TRAILS AT ASPEN RIDGE FILING NO. 5

FINAL GRADING & EROSION CONTROL PLANS

EPC STORMWATER REVIEW COMMENTS
IN ORANGE BOXES WITH BLACK TEXT

TRAILS AT ASPEN RIDGE- F5				
GRADING AND EROSION CONTROL PLAN				
GRADING & EROSION CONTROL PLAN				
DESIGNED BY:	CRD	SCALE:	DATE ISSUED:	DRAWING No.
CHECKED BY:	NMS	HORIZ. N.A.	OCTOBER 2021	GEC01
		VERT. N.A.	4 OF 7

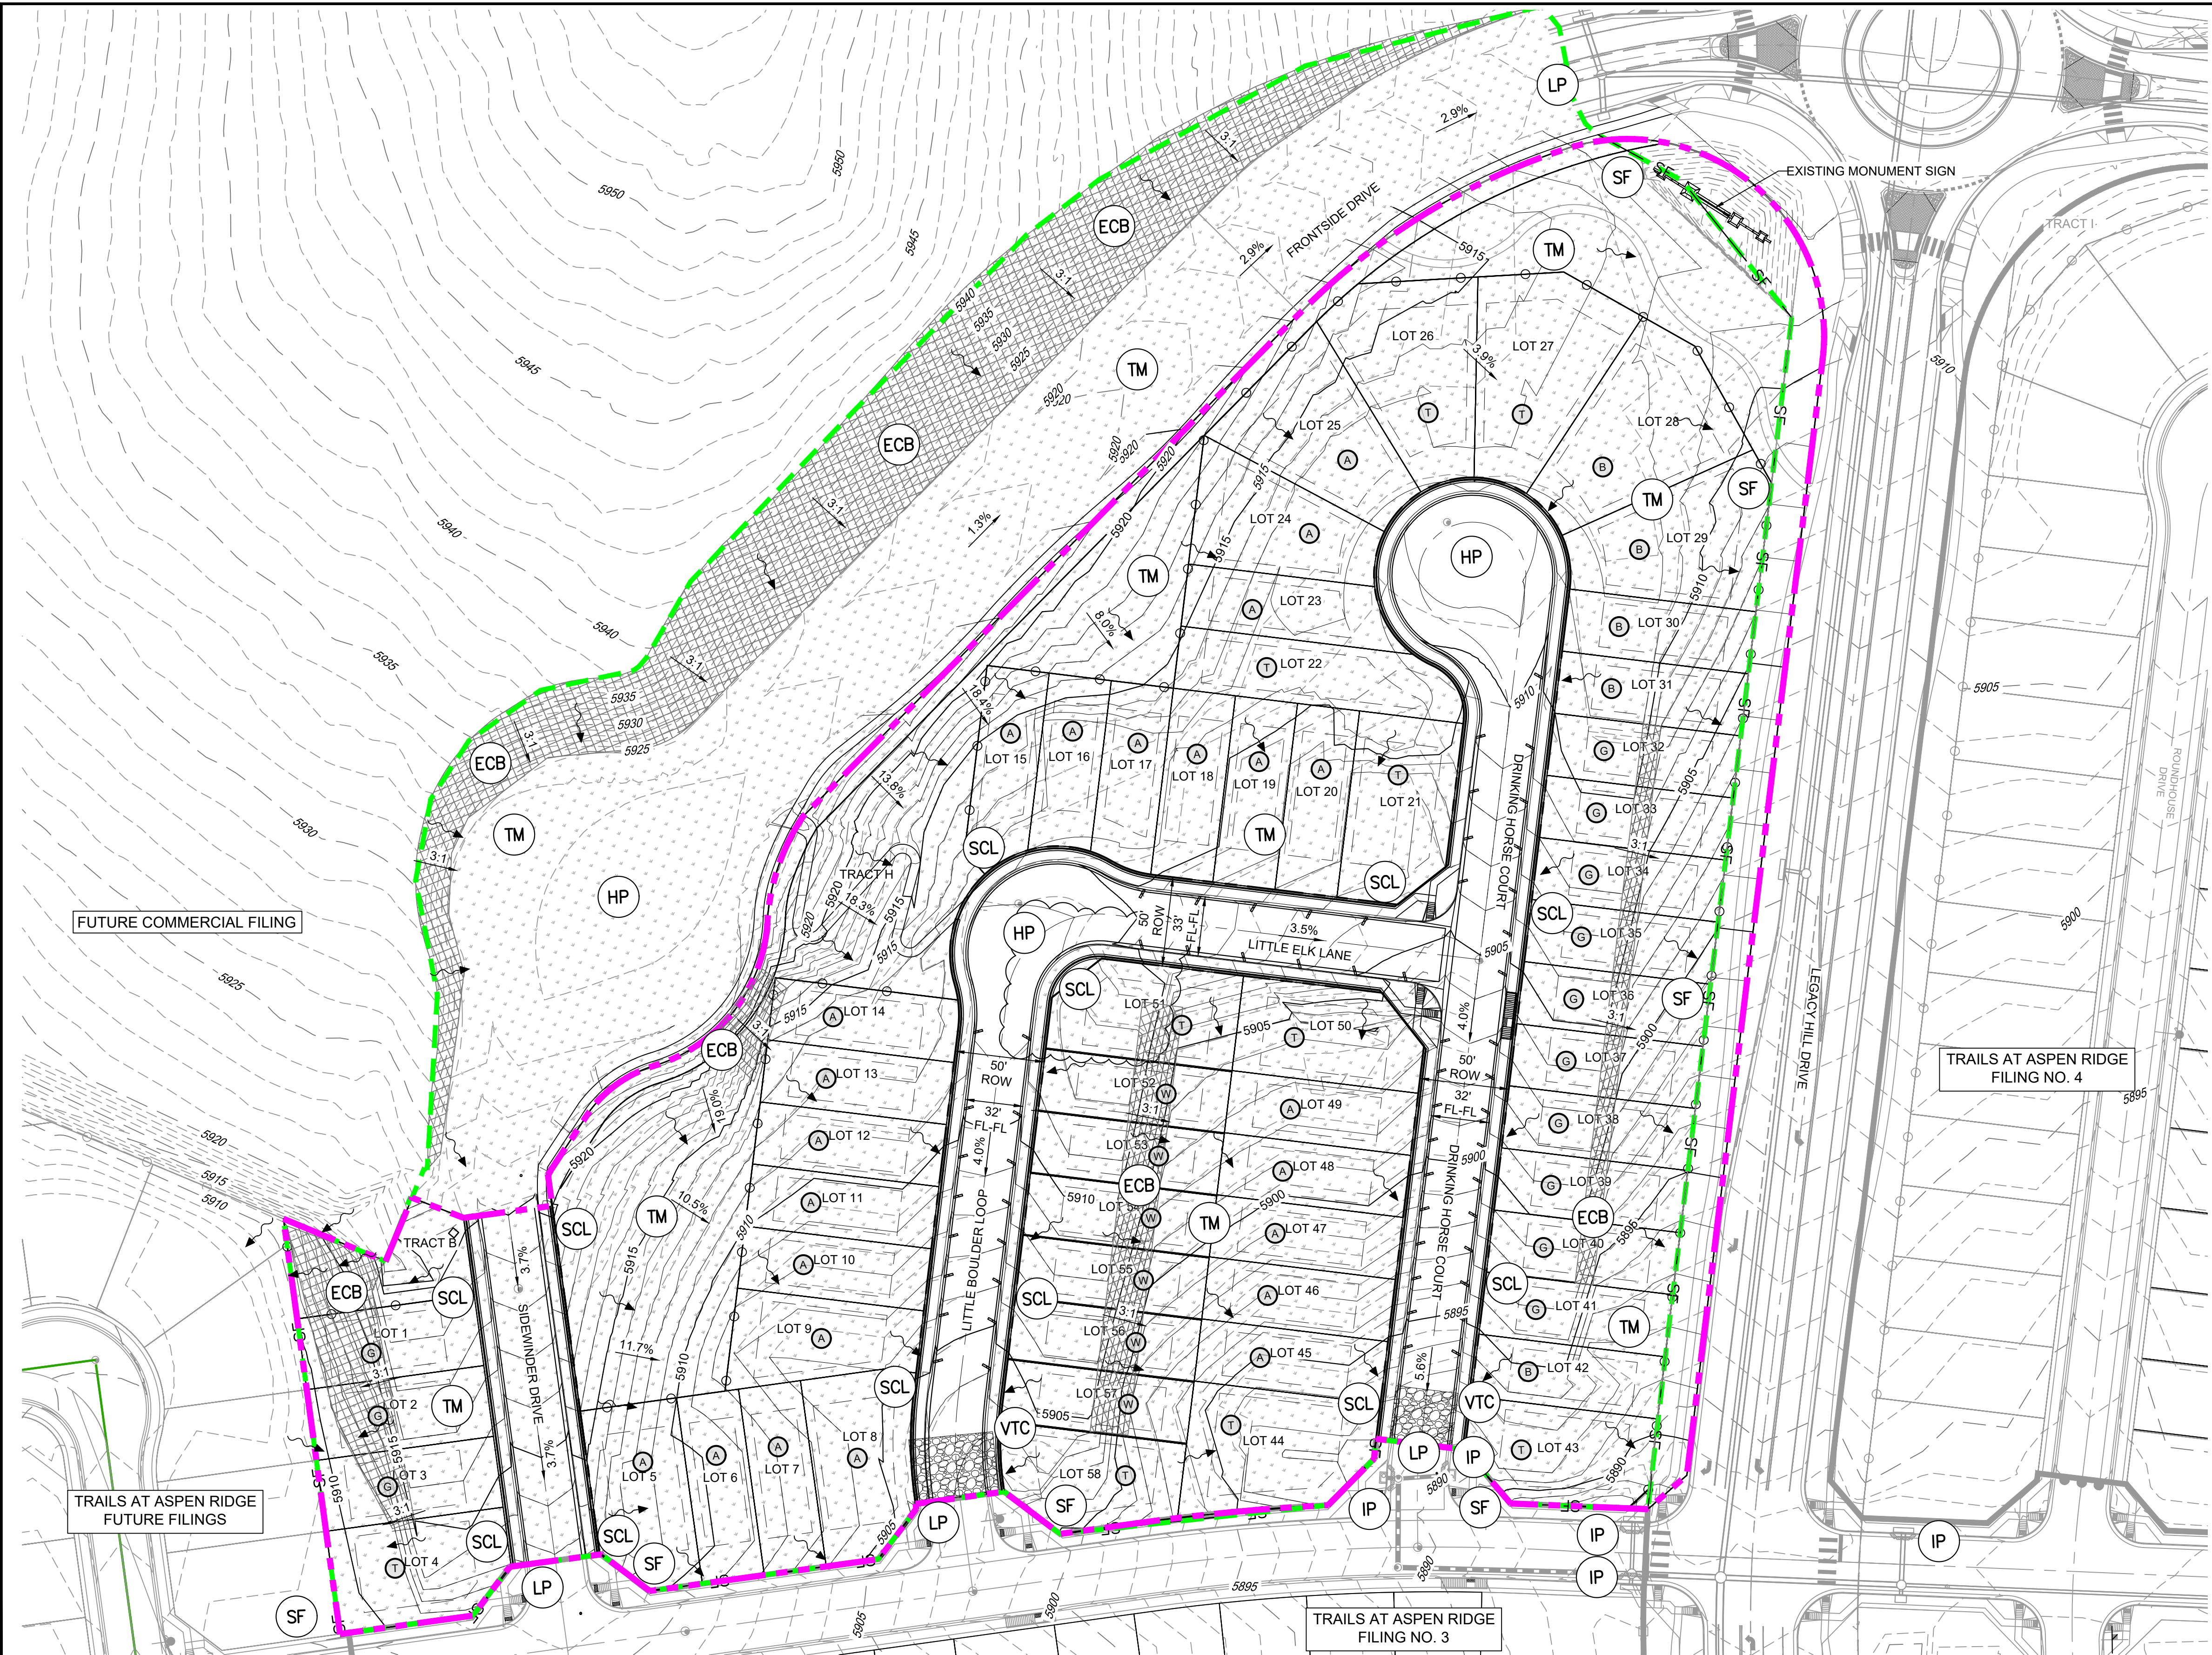
show ECB for this 3:1 slope as well.

Add ECB bubbles

update to tract B per plat

show SW piping.

show "grayed-out" existing IP
